**GAZCORP INDUSTRIAL ESTATE – 813-913 WALLGROVE ROAD, HORSLEY PARK
SSD-5248 – MODIFICATION 7 REQUEST FOR ADDITIONAL INFORMATION**

This letter is submitted to the Department of Planning, Housing and Infrastructure (DPHI) in response to a request for additional information dated 20 August 2025.

Figure 5: Asset Protection Zones

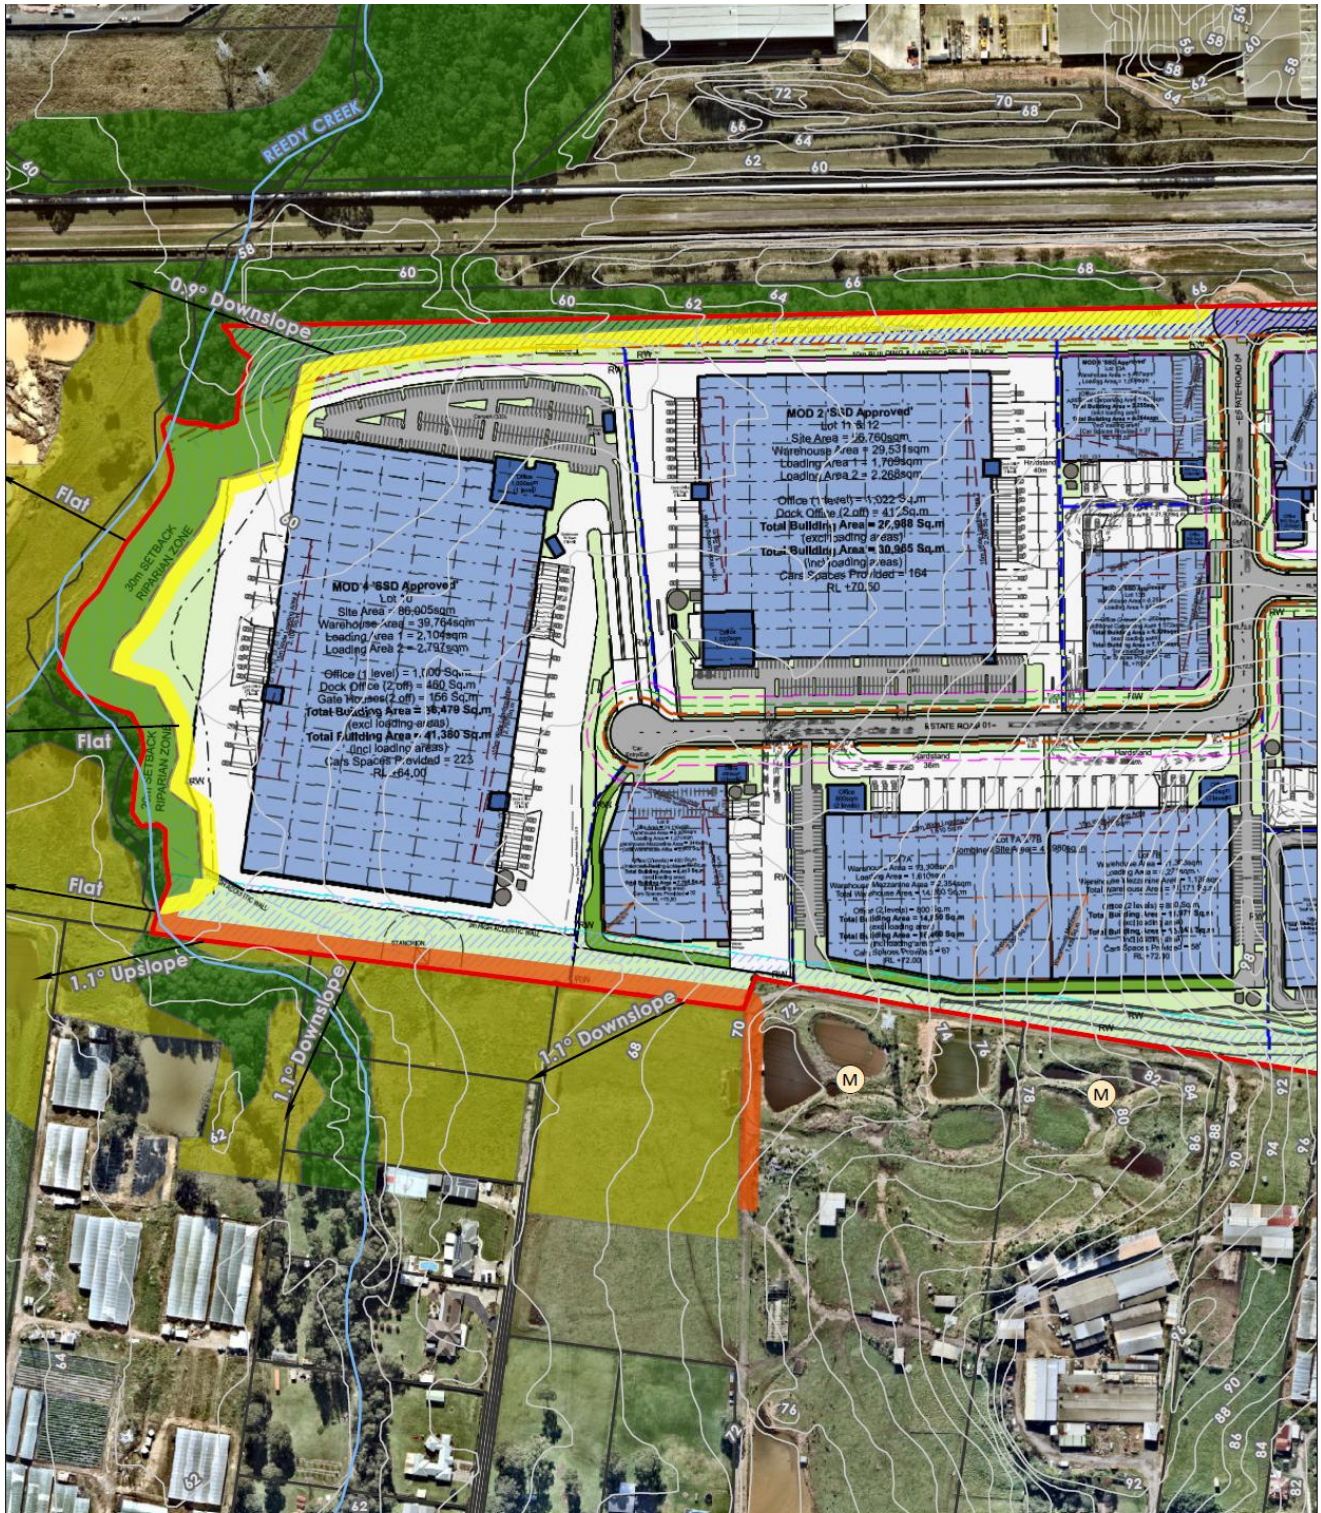
Based on the information provided, it is recommended that the subsequent stage of the referral be supplied with a bush fire report prepared by a suitably qualified bush fire consultant addressing the relevant sections of Planning for Bush Fire Protection 2019.

Refer to assessment at **Section 1.1** below.
The proposed modification complies with the requirements of Planning for Bushfire Protection 2019, particularly in regard to public road access, internal road access, water, electricity and gas and landscaping.

Asset Protection Zones (APZs) are shown at **Figure 1** and the Bushfire Attack Levels (BAL) are shown at **Figure 2**.
